**KIRKLEES METROPOLITAN COUNCIL
INVESTMENT & REGENERATION SERVICE**

DELEGATED DECISION TO DETERMINE PLANNING APPLICATIONS

Reference No:	2025/62/91940/E
Site Address:	69, Chapel Lane, Heckmondwike, WF16 9JR
Description:	Erection of two storey side extension and single storey front and rear extensions with balcony above, dropped kerb and associated alterations
Recommending Officer:	Elenya Jackson

DECISION – Refused

Client		Mr & Mrs Hussain	
Job		69 Chapel Lane Heckmondwike	
Title		Proposed Ground Floor Plan	
Drawn By	RK	Date	June 2025
Eng. Check		Scale	1:50
Tech. Check			
Drawing No.		Rev.	
2025 / 493 / 04

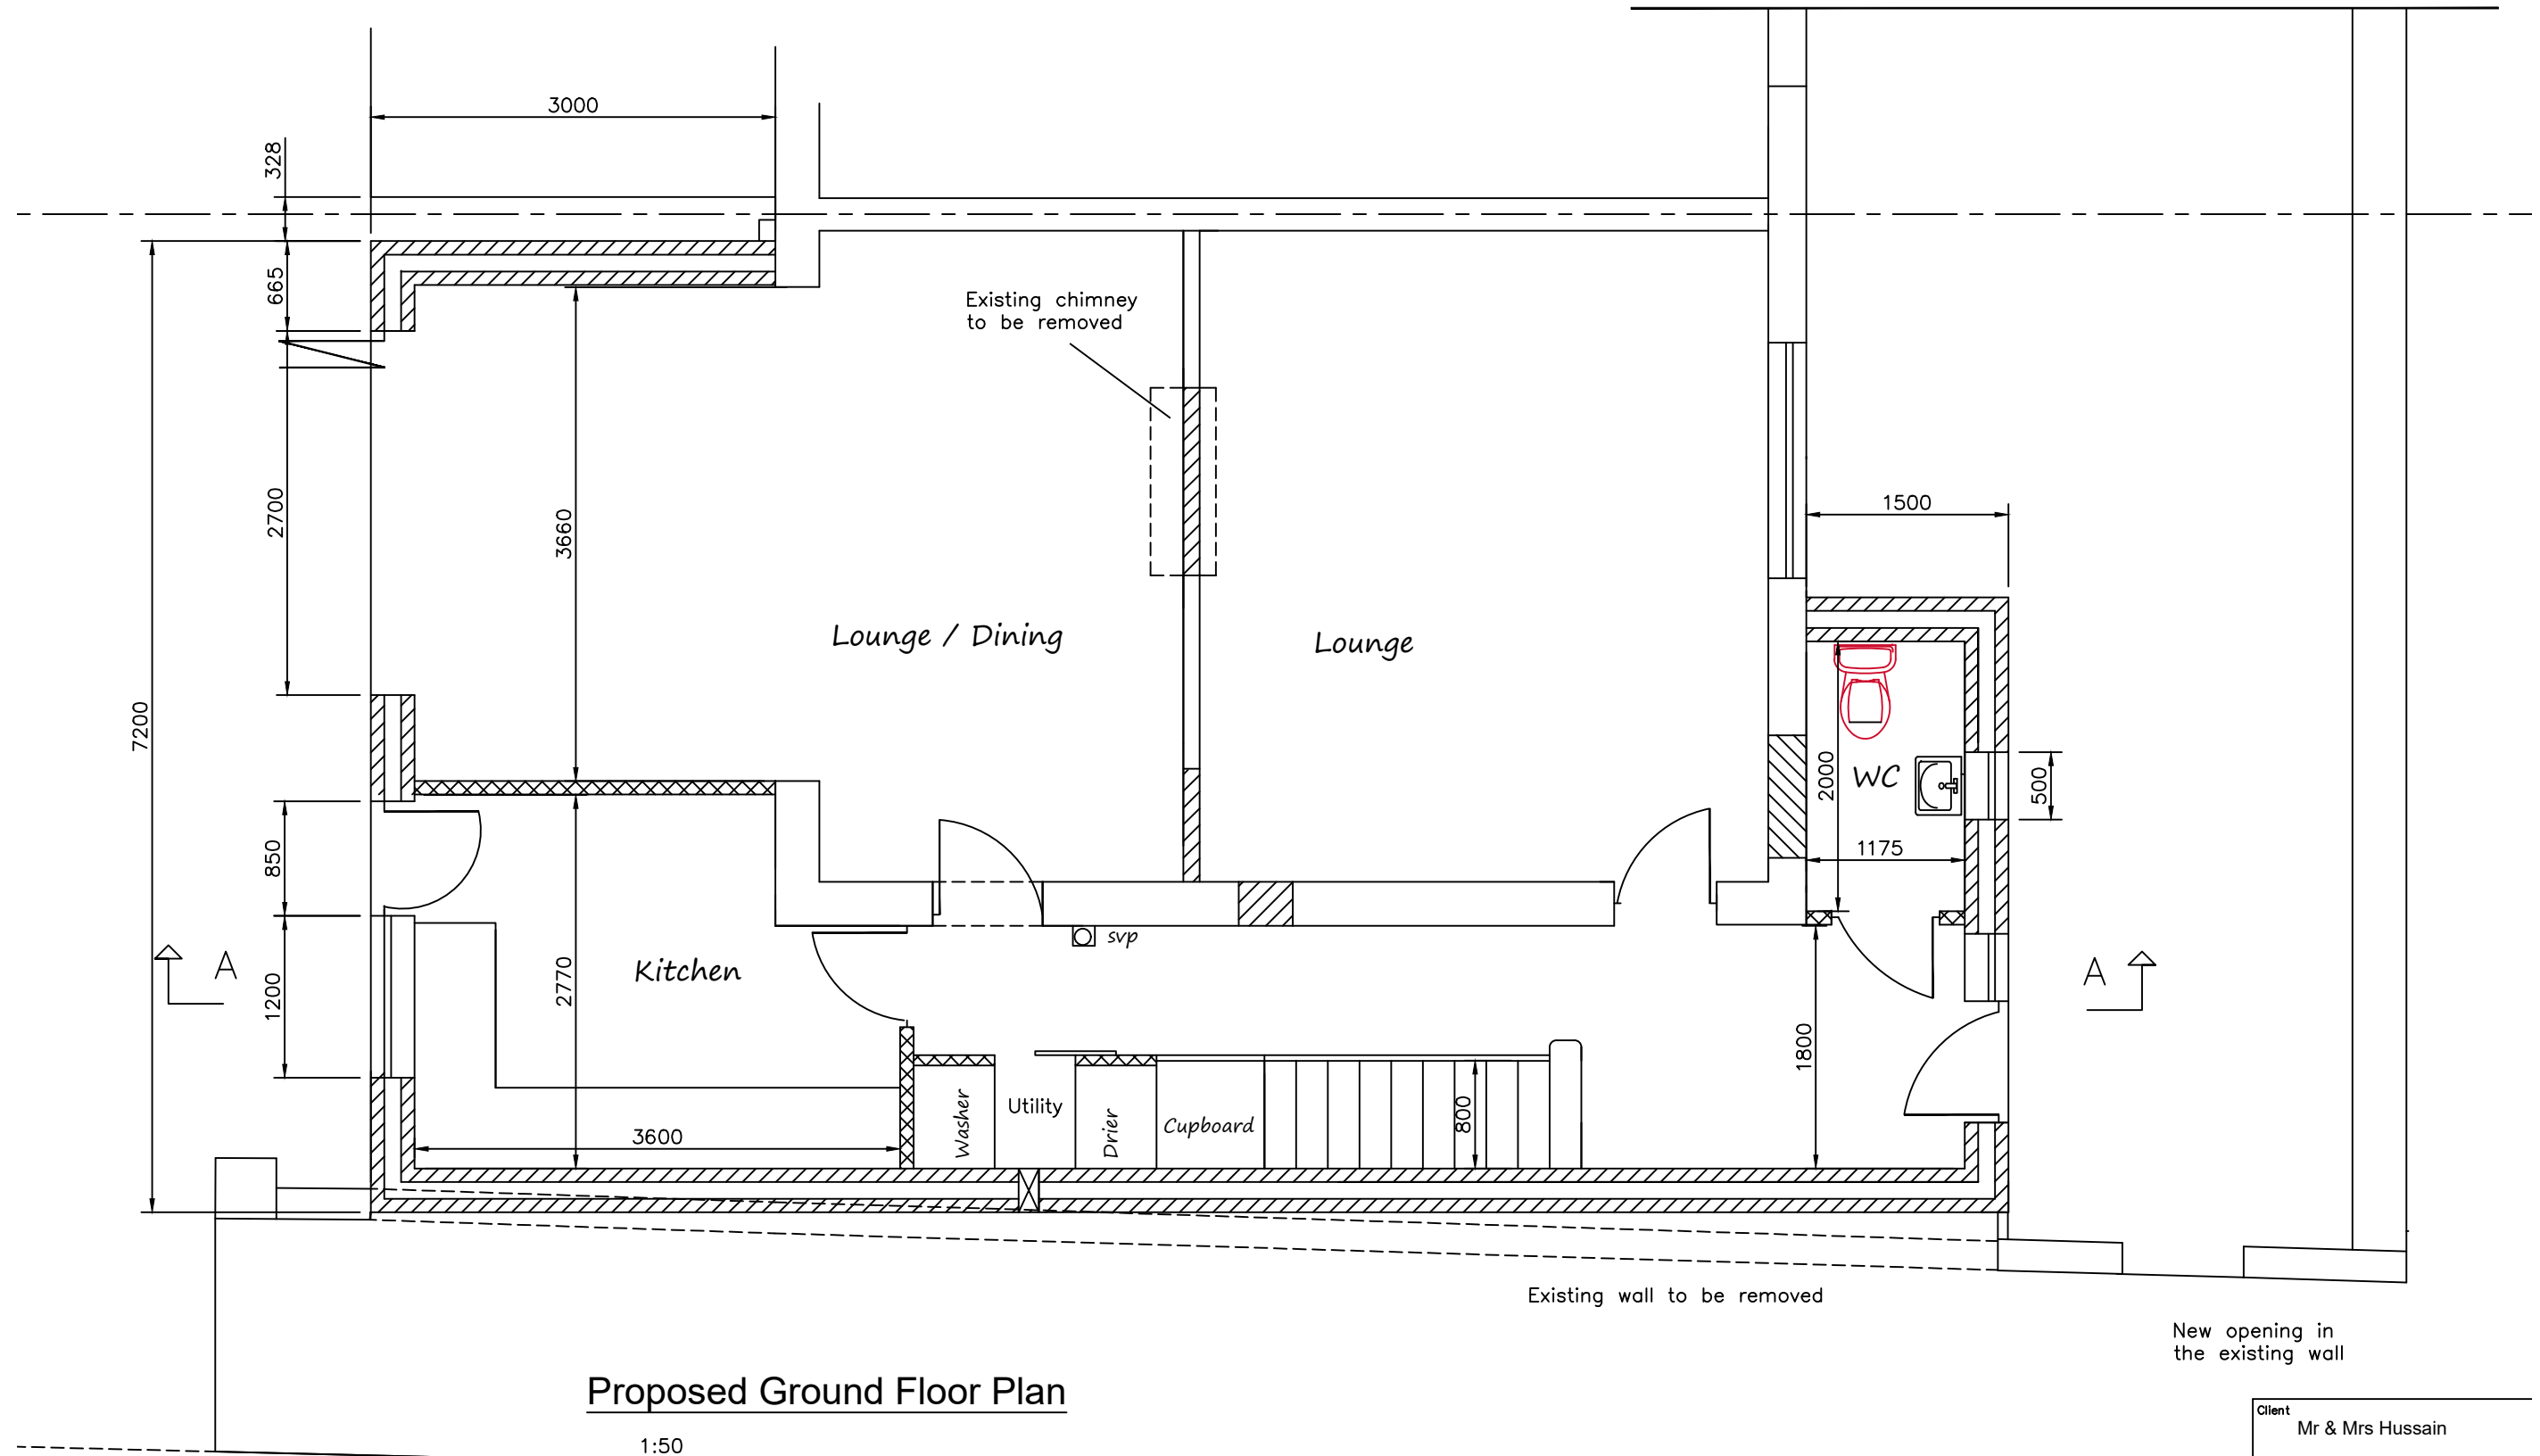
The proposal would increase the height of the boundary treatment to 2m in height immediately adjacent to the highway which would obstruct visibility splays. The proposed entrance gates would not be set a sufficient distance into the plot which would result in a vehicle having to wait in the highway for the gates to open, the proposal would impact pedestrian intervisibility and adversely impacting on highway safety. In addition, the location of the car parking spaces does not appear to be accessible as the proposed gate would intercept parking space 2.

Proposed Front Elevation (East)

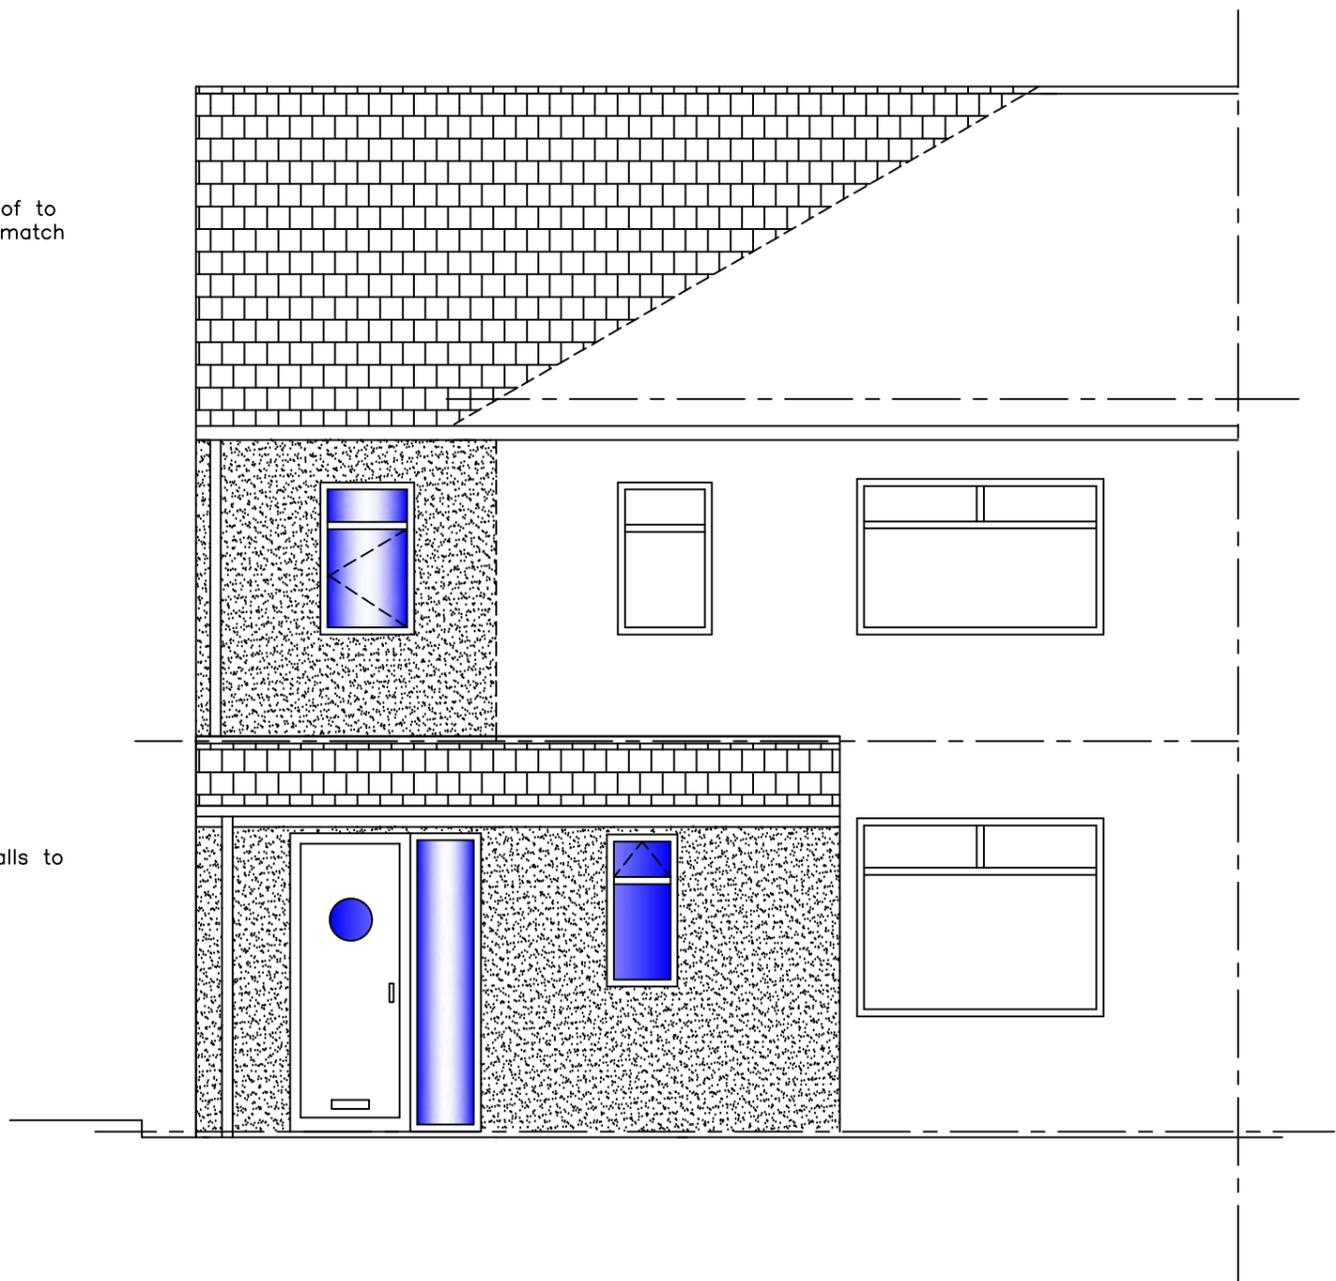
The front extension is considered to be acceptable from a visual perspective.

Proposed Rear Elevation (West)

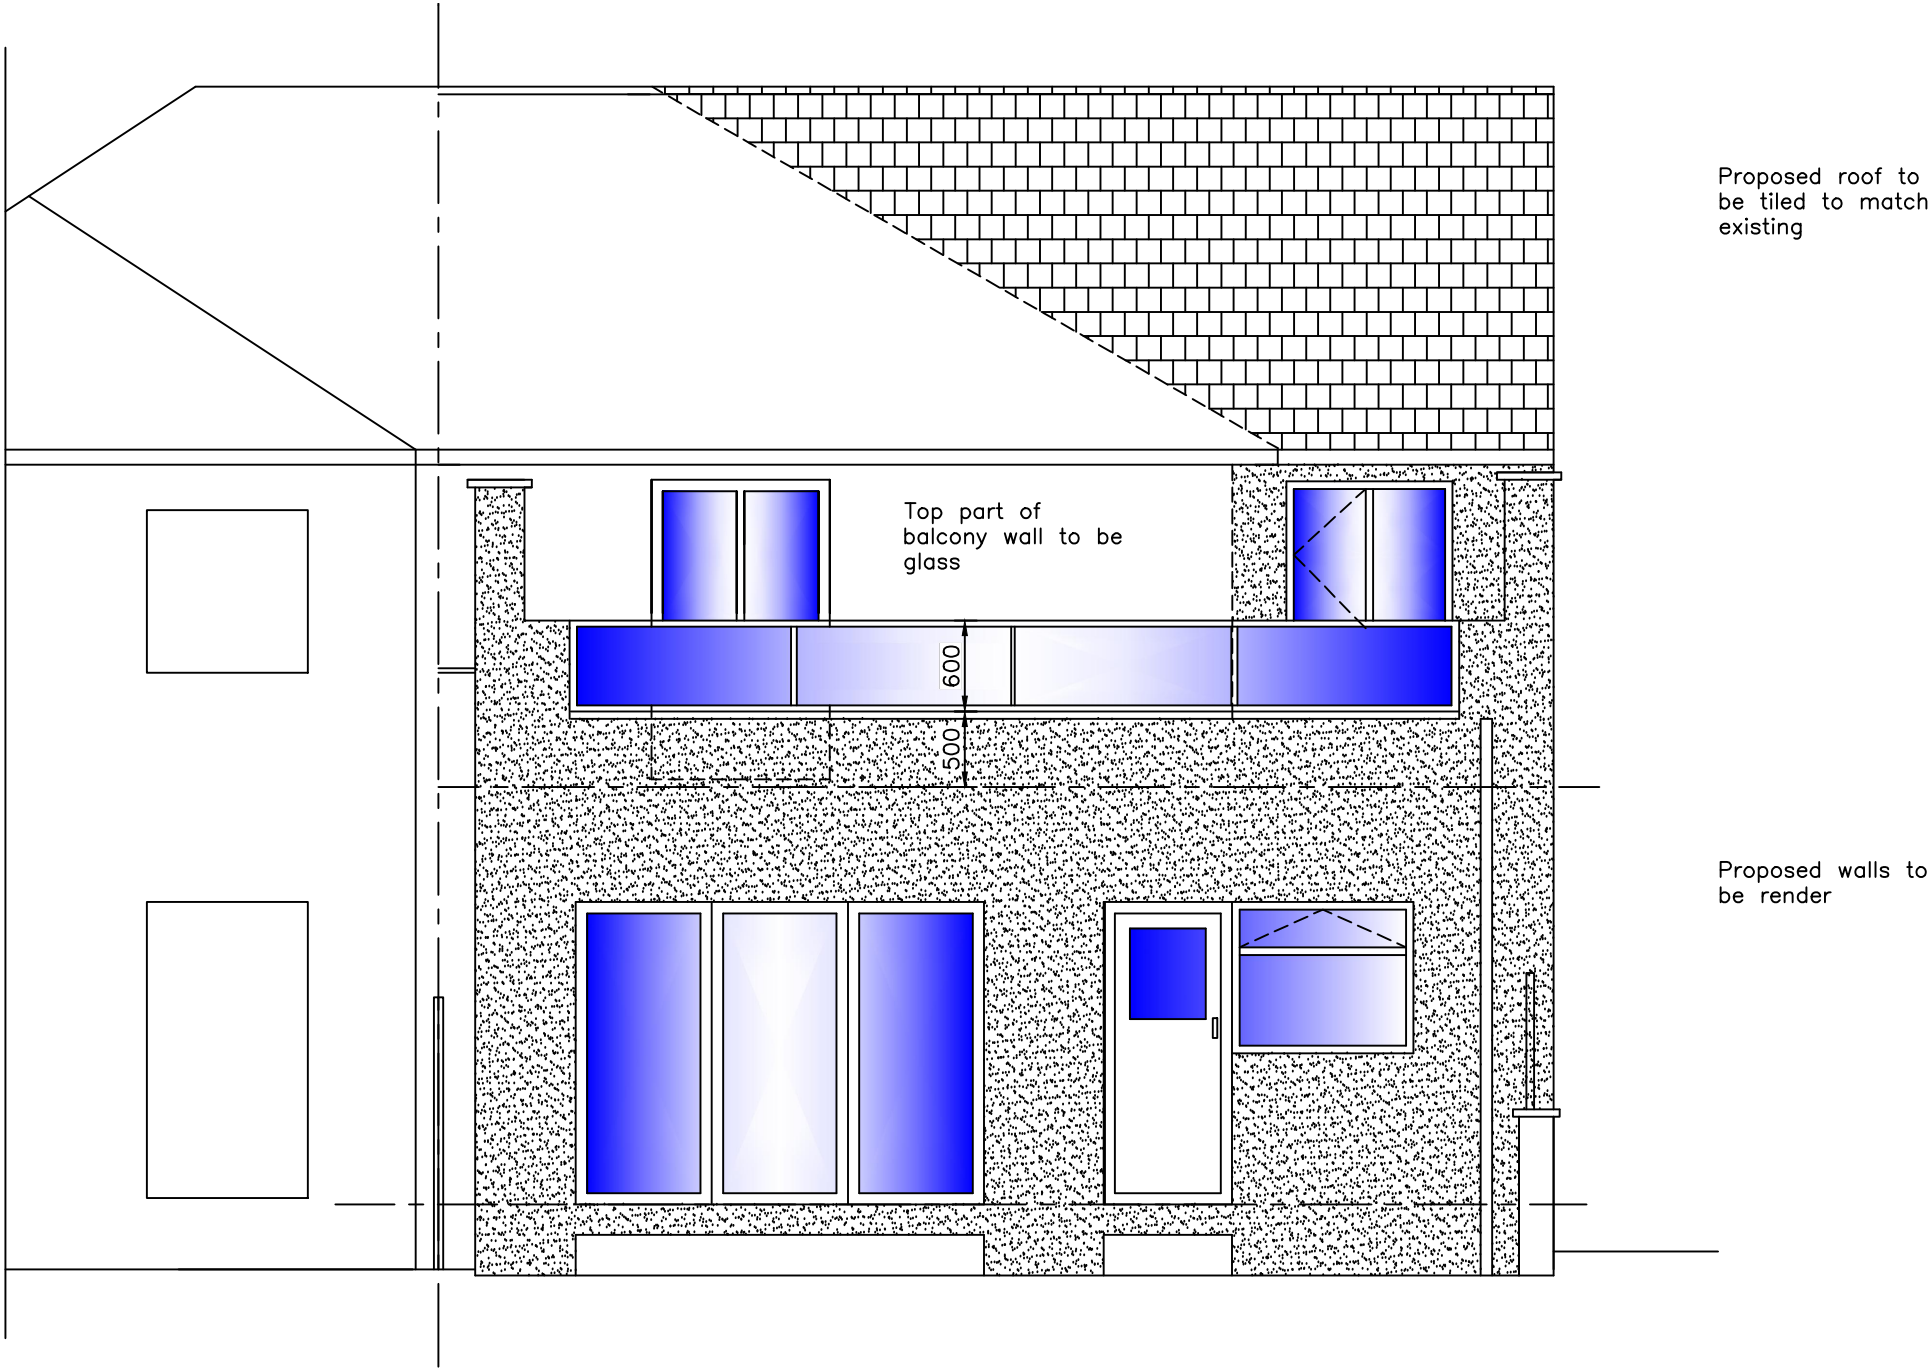
Officers have reviewed the two storey element of the proposal and consider that it would extend an appropriate distance beyond the rear elevation of the host dwelling. However, the proposed rear extension would appear to feature a flat roof due to the first floor providing a balcony area due to the existing

amenity space being utilised for parking for this proposal. Due to the property occupying a corner plot this would be extremely visible from the public realm. The rear extension would appear as a bulky, prominent and out of keeping feature which would not integrate with the host dwelling and would appear as a dominant feature in the street scene.
